Design Excellence Strategy for 42 Honeysuckle Drive (SSD 8440)

Attachment - UDCG Meeting Minutes 19 July 2017

URBAN DESIGN CONSULTATIVE GROUP MEETING

Date of Panel Assessment:	19 th July 2017
Address of Project:	42 Honeysuckle Drive, Newcastle
Name of Project (if applicable):	N/A
DA Number of Pre-DA?	Pre-DA UDCG No.2017/00012
No. of Buildings:	One
No. of Units:	52 residential, 5 serviced apartments, 144 hotel rooms, small retail area, and 256 parking spaces.
Declaration of Conflict of Interest:	Nil.
Attendees:	<u>Applicant</u> Patrick Quinlan Chris Farrington Gavin Edgar Ben Young Alan Valentino <u>Council</u> David Paine

The proposal has a variety of communal spaces accessible to the public, residents and guests.

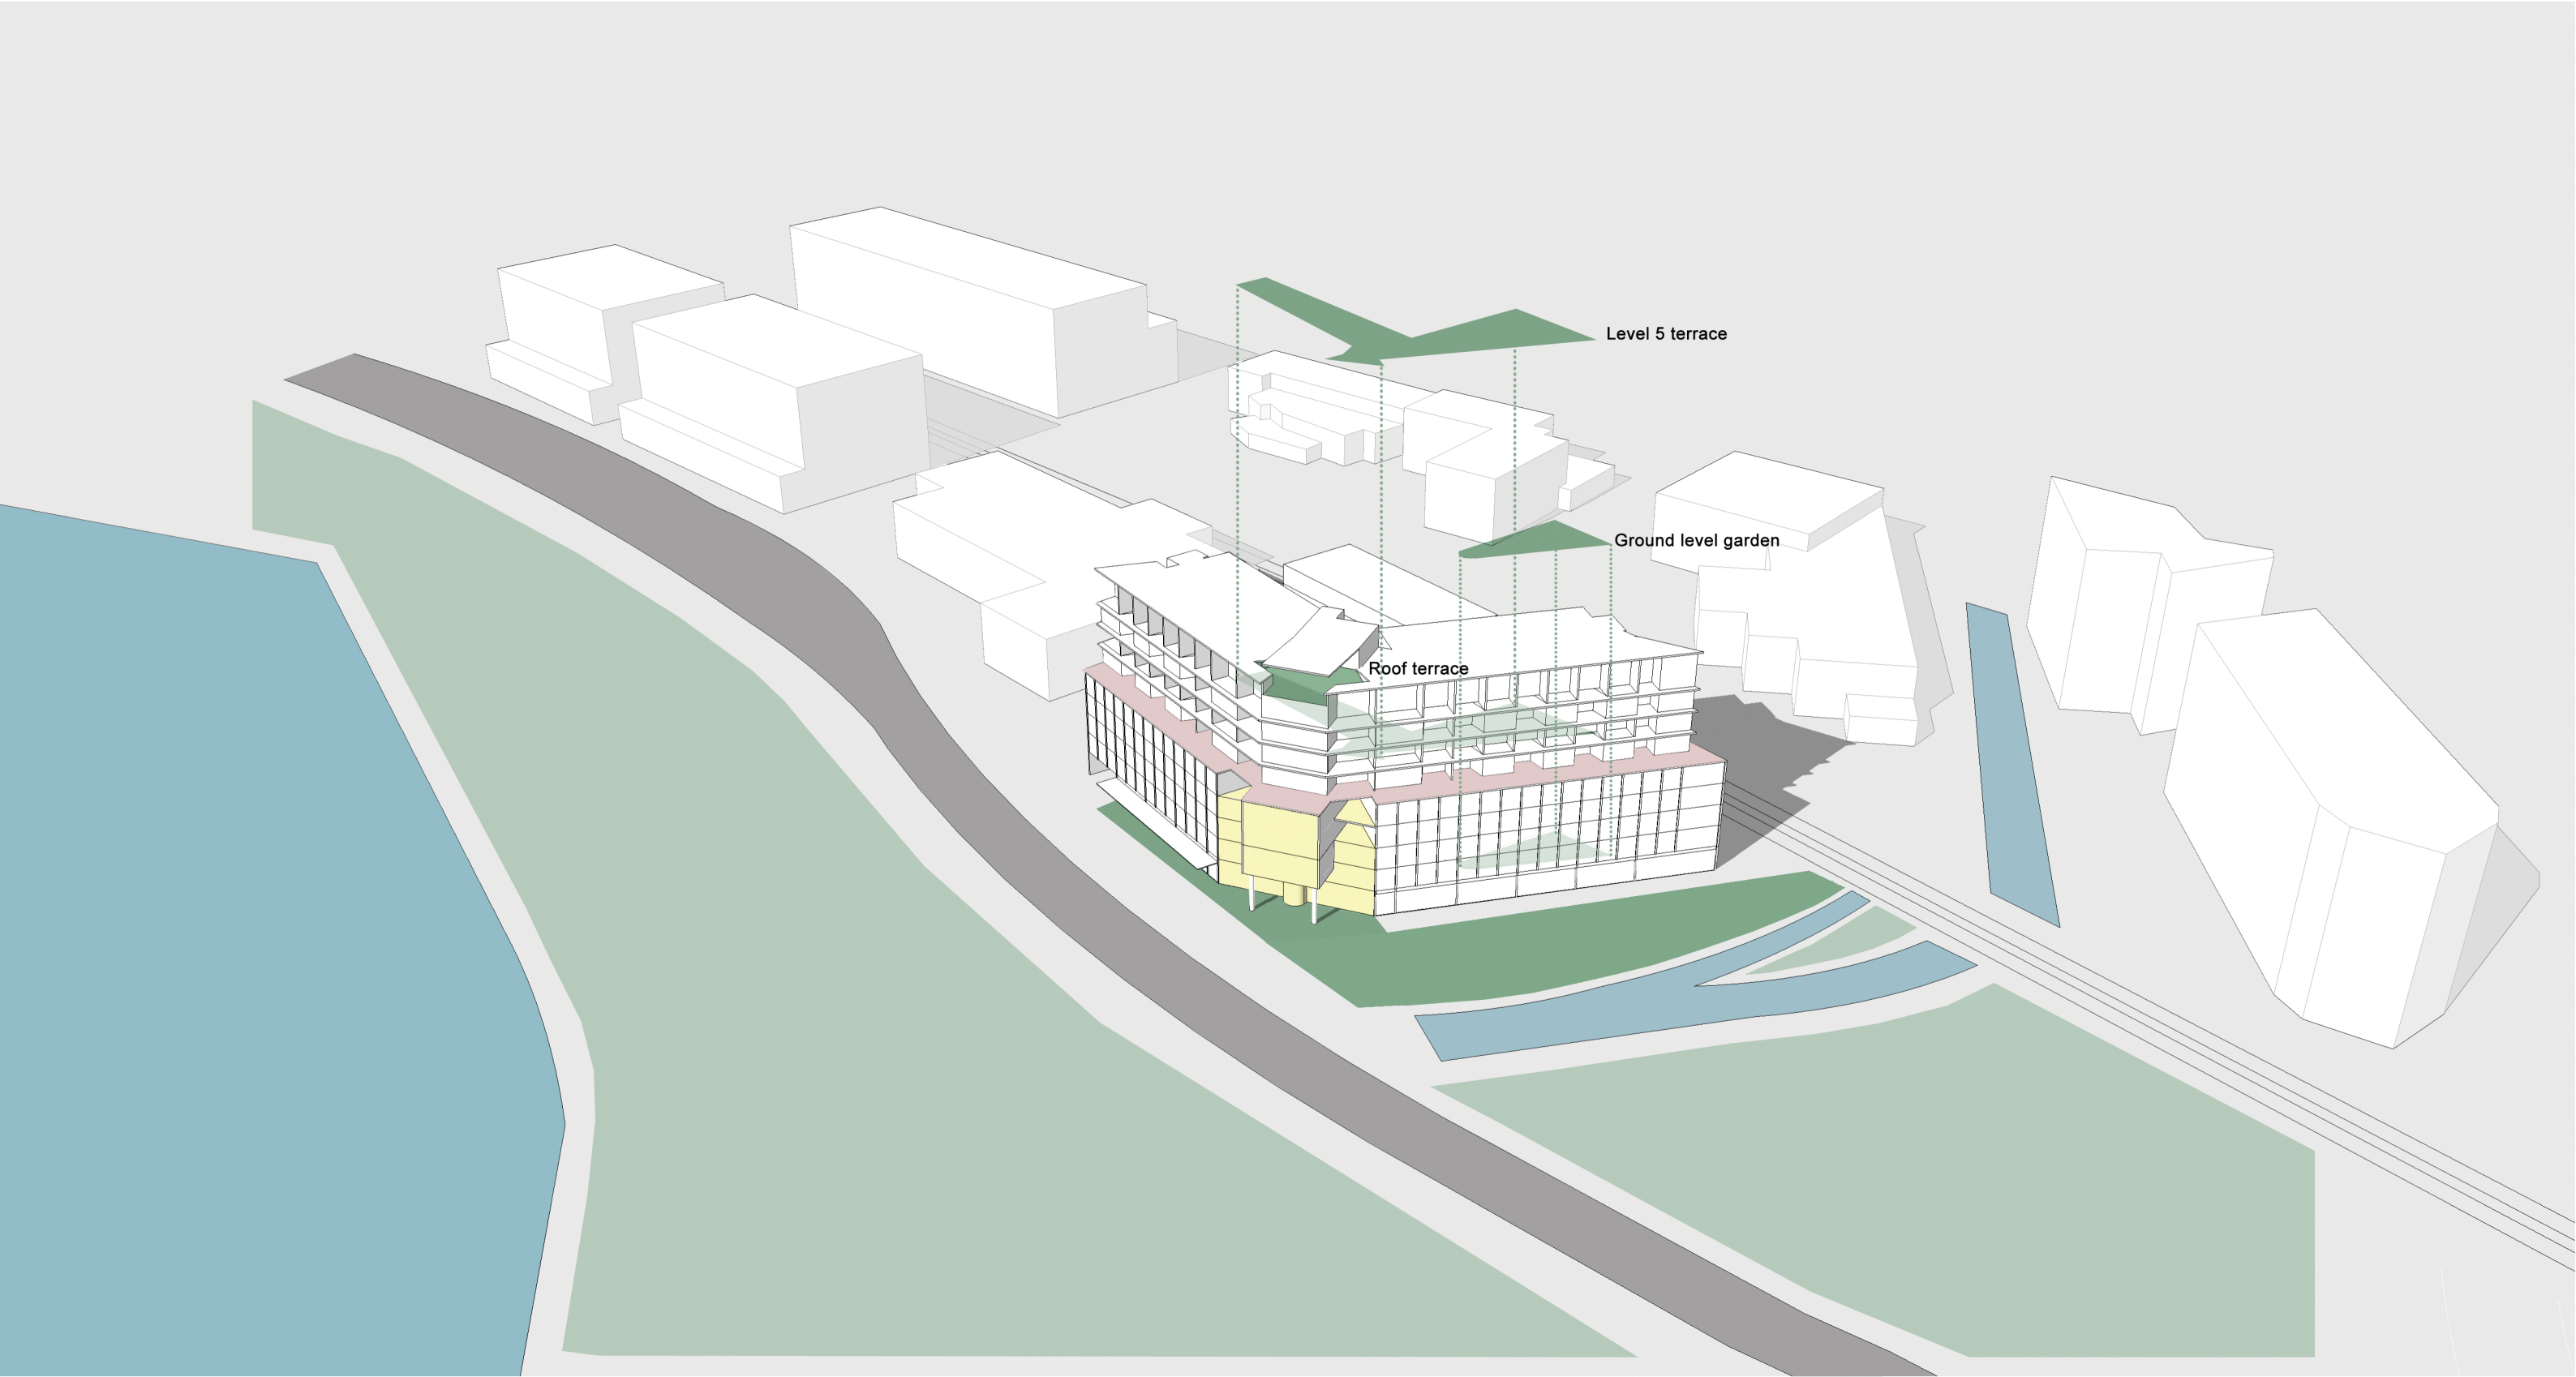
- .Provide communal facilities in the Level 5 courtyard, potentially at the southern end accessed from the covered walkway where suggested at the meeting. This could include a cantilevered balcony, and a small pavilion fitted with kitchenette

facilities, with afternoon sunlight and good outlook over the future landscaped public area. Landscaping of the courtyard should take into account that it is very likely that there will be small children in residence so that a toddlers' play area with for example a sandpit could be included.
